DRB Application No.: 10DRB-70029 Project # 1007864
 Project Name: New Holiday Park
 Agent: Modulus Architects Phone No.: _____

City of Albuquerque
Planning Department
Inter-Office Memorandum

SUBJECT: Project # 1007864

On August 21, 2009, the Environmental Planning Commission approved Project #1007864, 09EPC-40035, a Site Development Plan for Building Permit, for all or a portion of Tract B, New Holiday Park, located on Montgomery Boulevard NE between Juan Tabo NE and Tramway NE containing approximately 4.9 acres.

SUNFLOWERS - HEIGHTS PLAZA
N.E.C. OF JUAN TABO AND MONTGOMERY
ALBUQUERQUE, NEW MEXICO
STEPHEN DUNBAR, AIA SUNFLOWER
RMC
LANDSCAPE PLAN

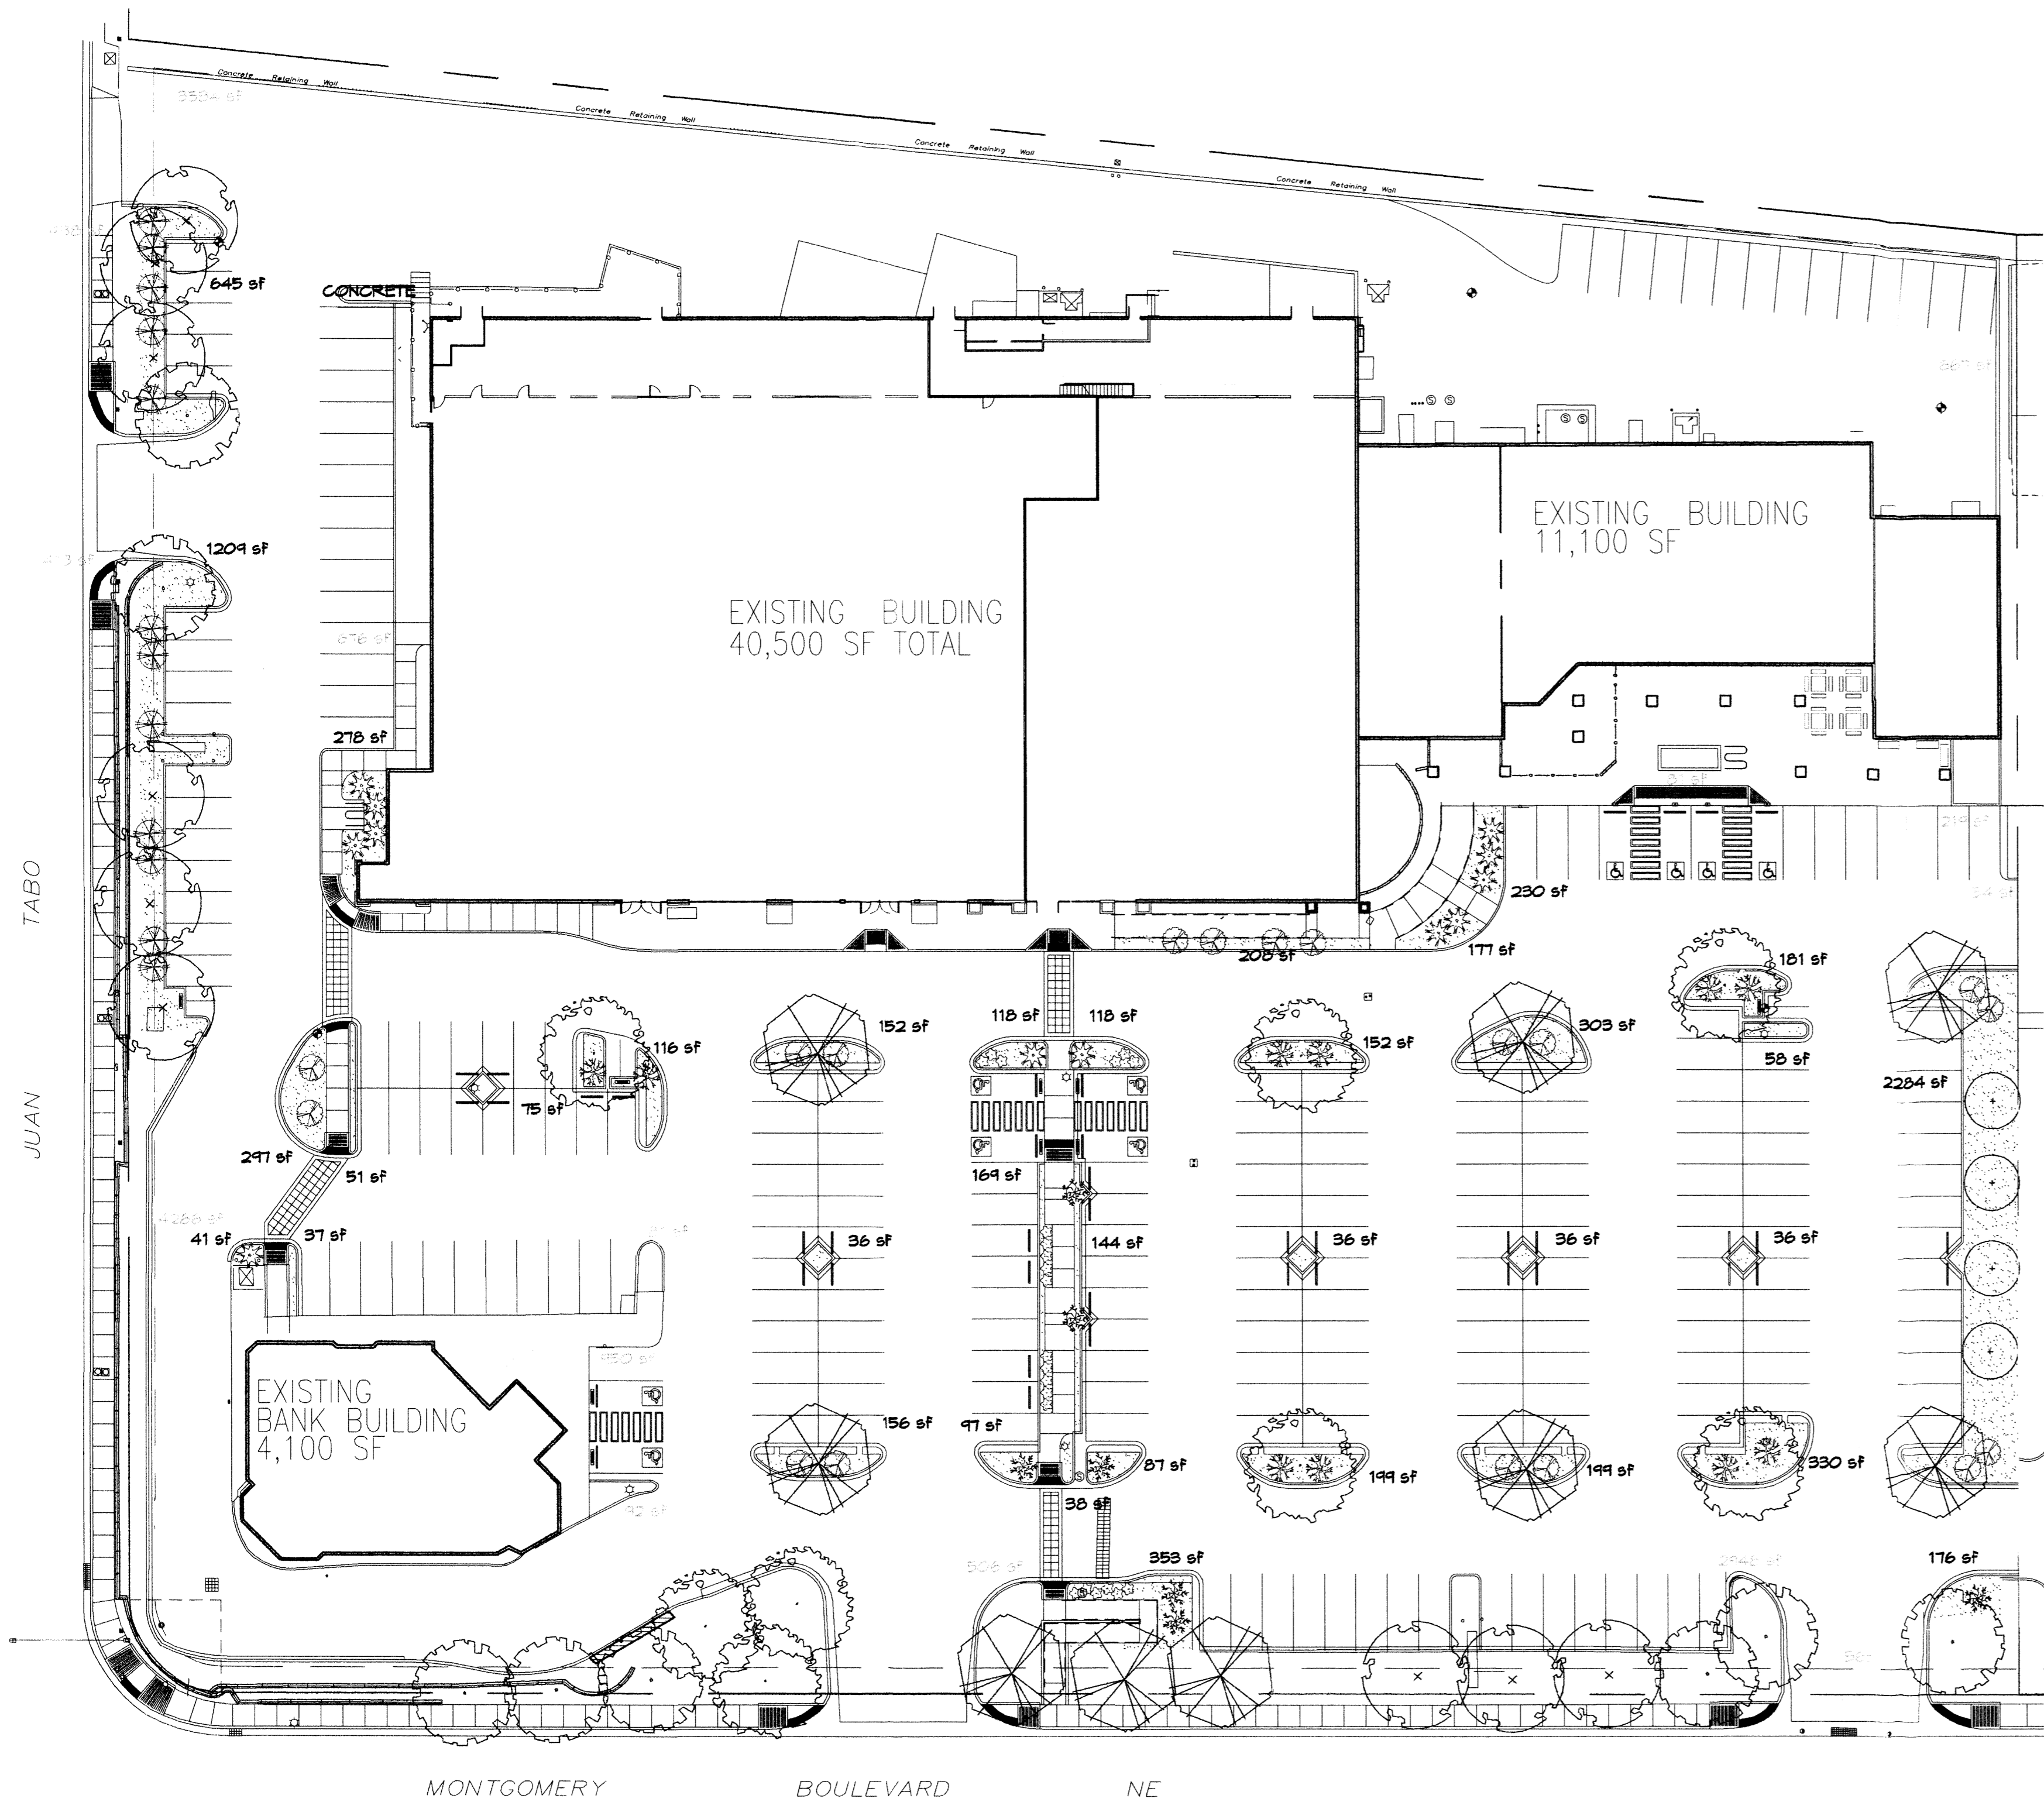
8a: There shall be a mixture of at least 4 species of street trees in order to comply with the street tree ordinance.

There are 4 species of trees along Montgomery Boulevard, but not along Juan Tabo Boulevard, which only has 3. This condition only applies to street trees.
